Our Ref: 21/01317/FUL

PROPOSAL: Proposed two-storey rear extension.

LOCATION: Orchard House 12 Eastern Road Brightlingsea Colchester

Client	David & Lesley Taylor	
Project title	Rear extension at: 12 Eastern Road, Brightlingsea CO7 0HU	
Drawing title	Existing floor plans	
Scale	1:50@A2	
Date	30/06/21	
Dwg No		Rev No
0344/PL/01

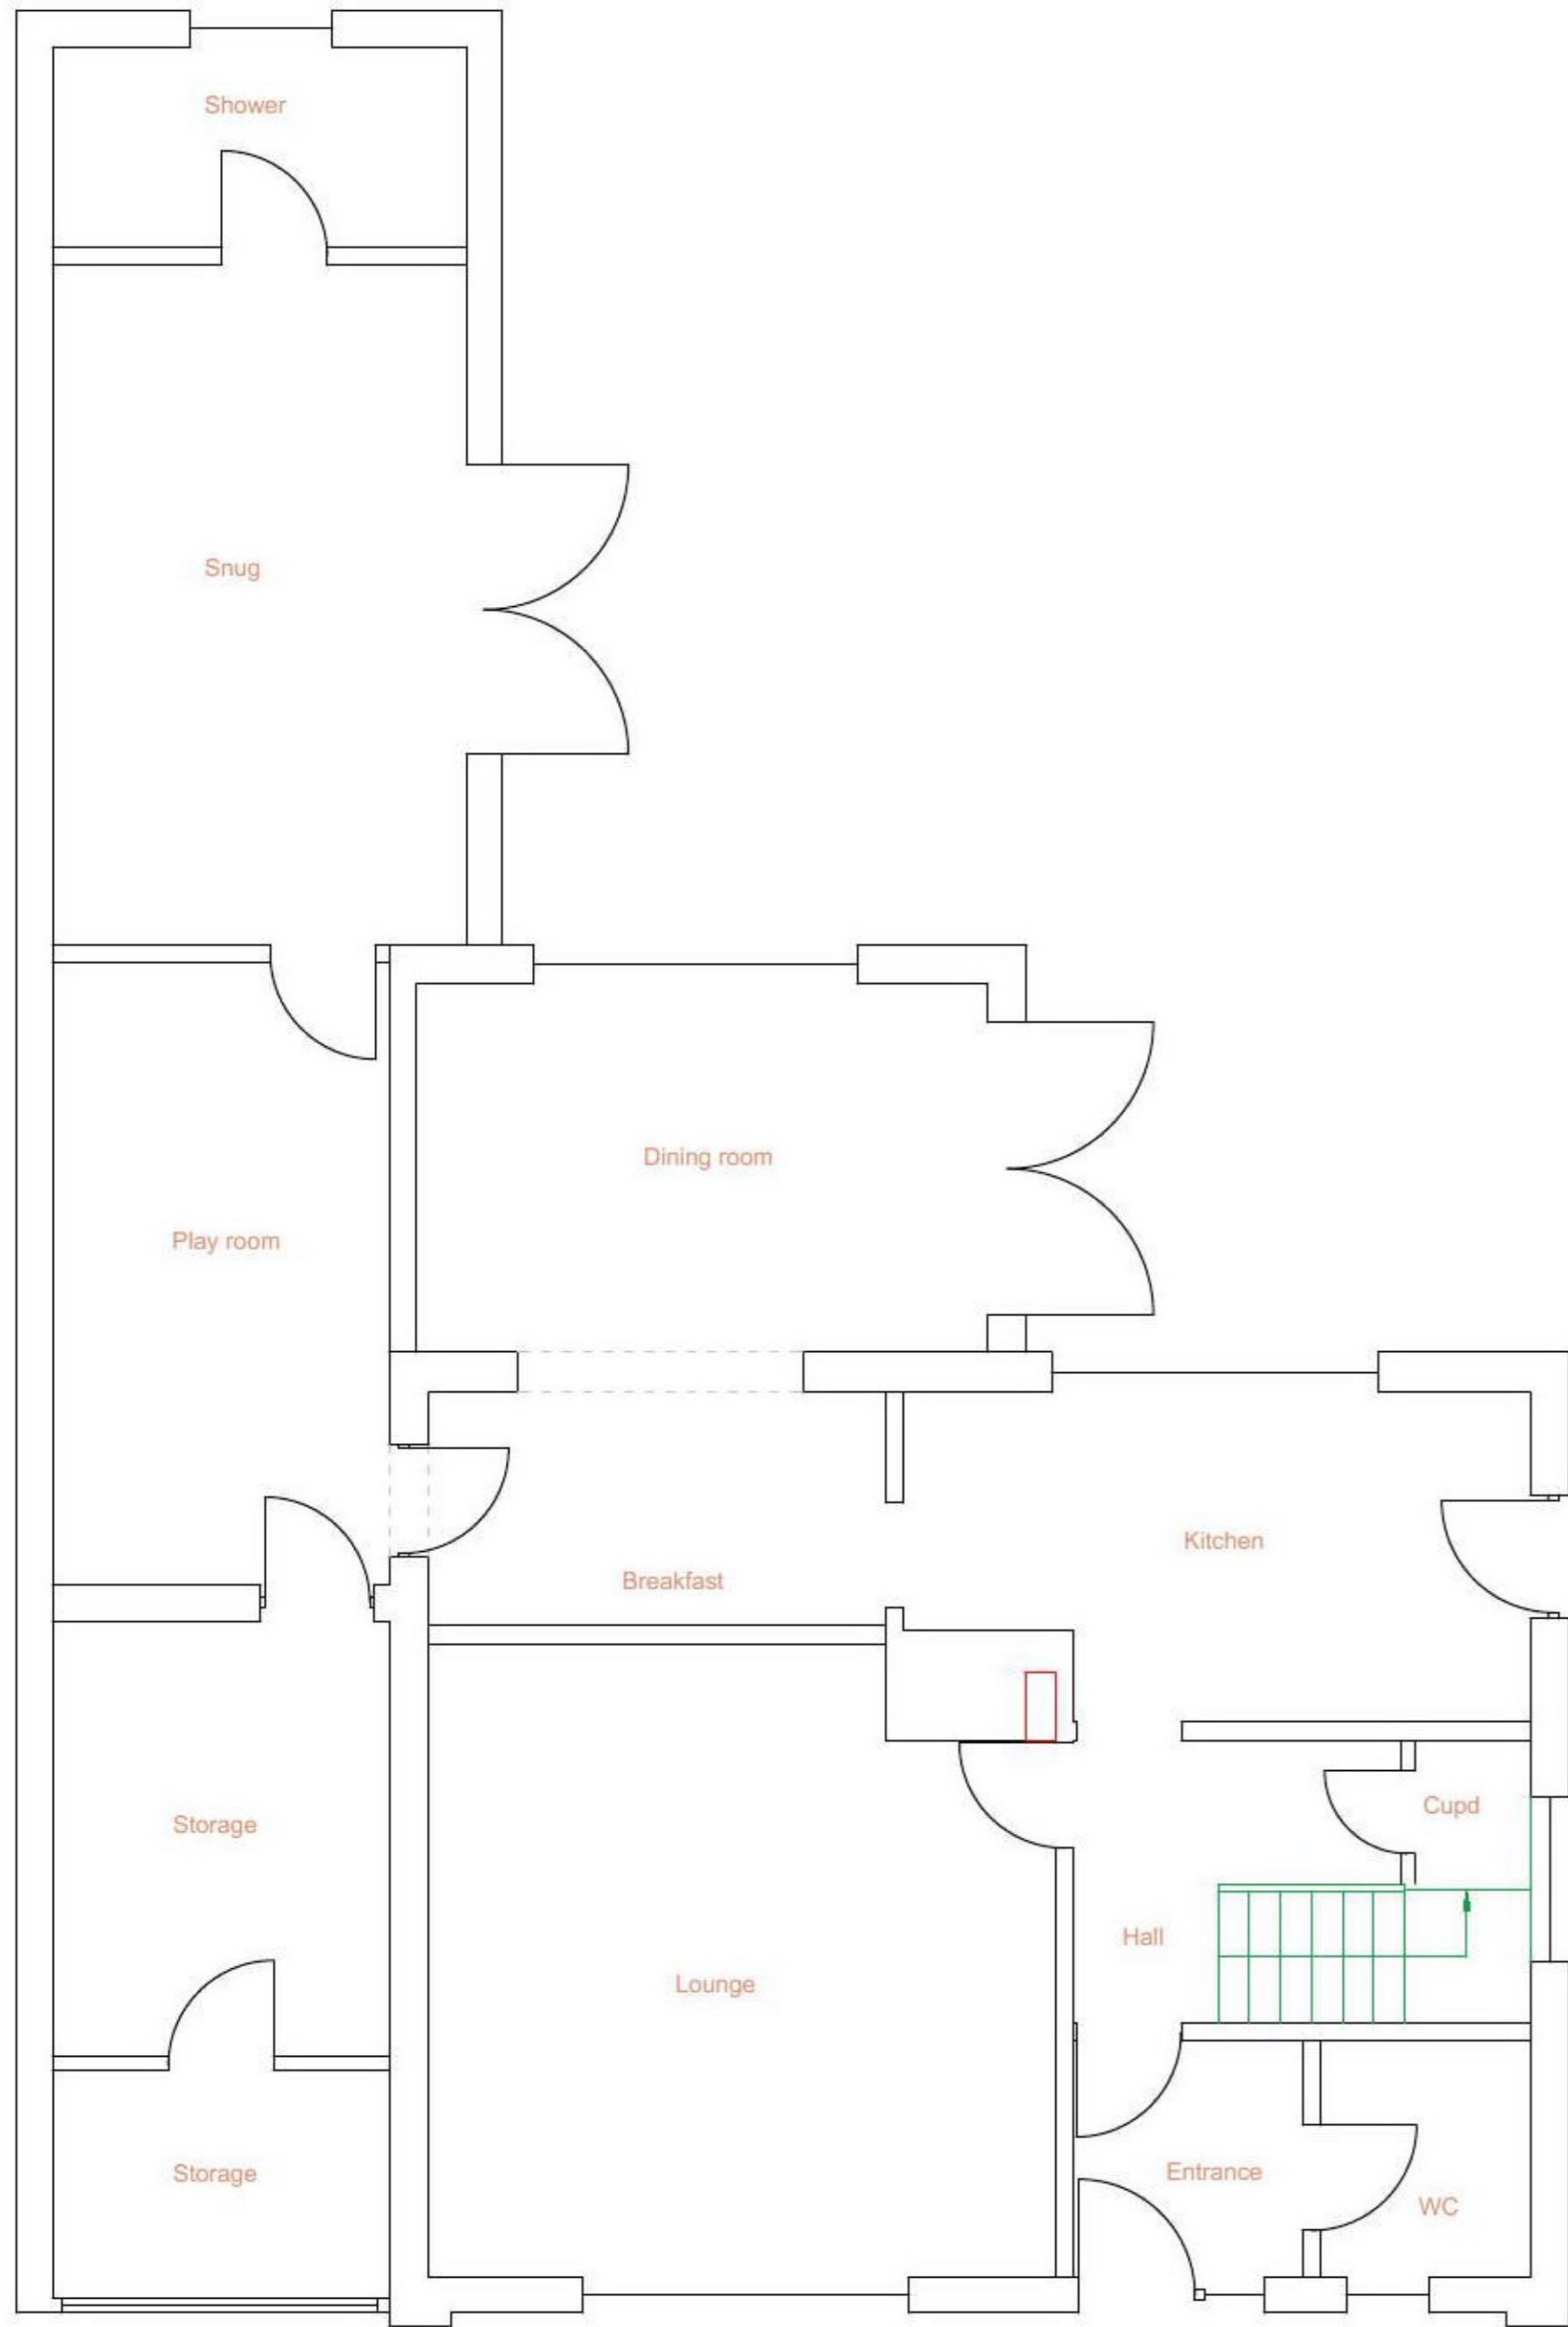
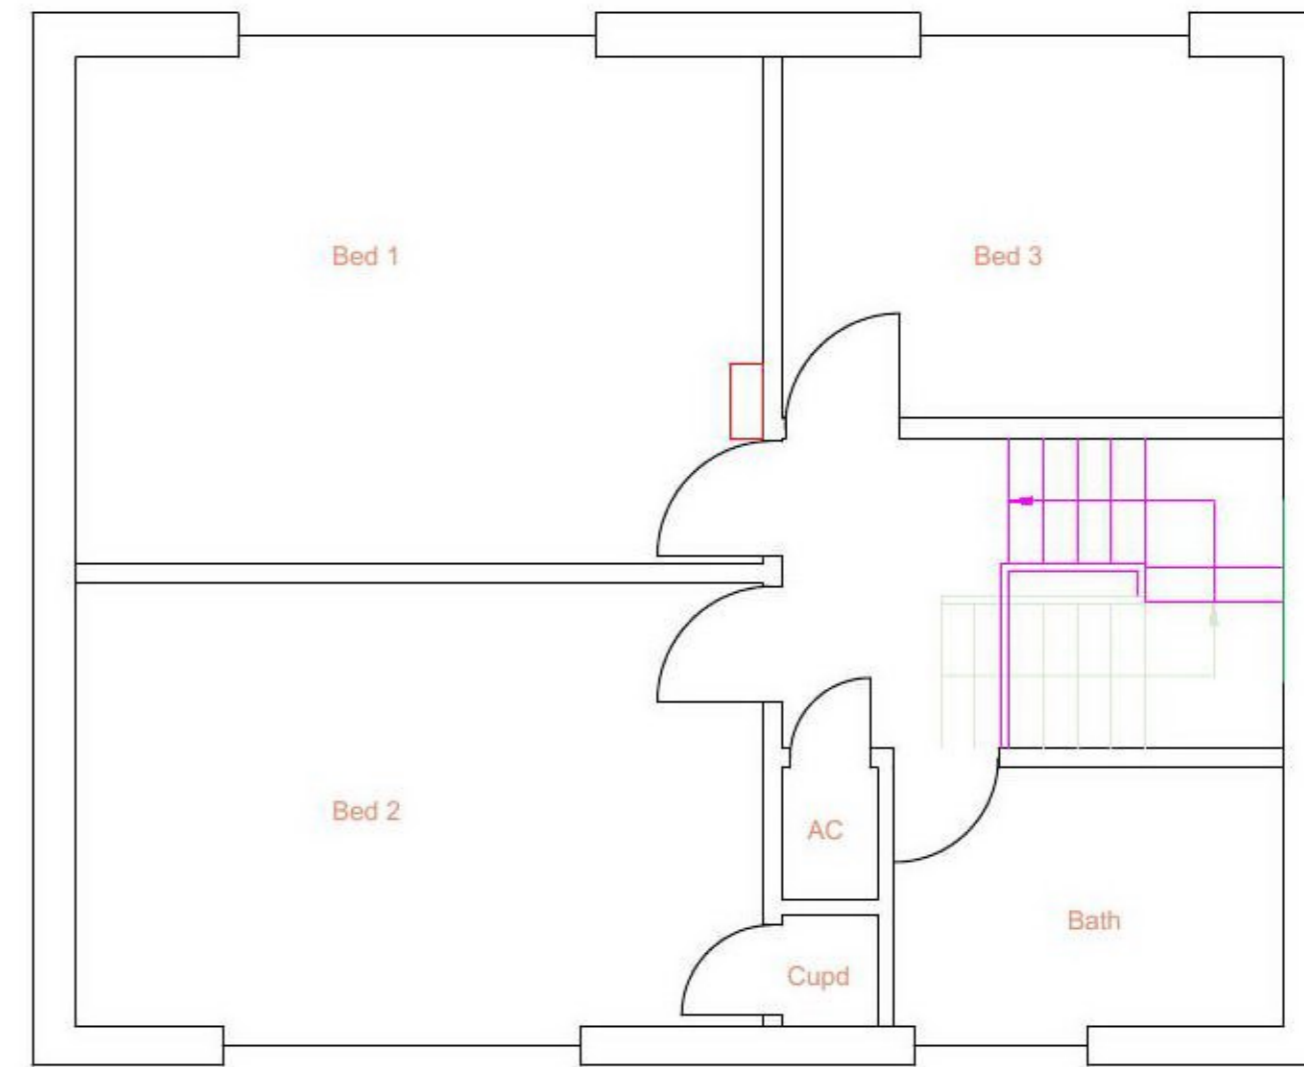
There are some existing openings shown on the existing floor plan which are not shown on the side elevation. Please update plans accordingly.
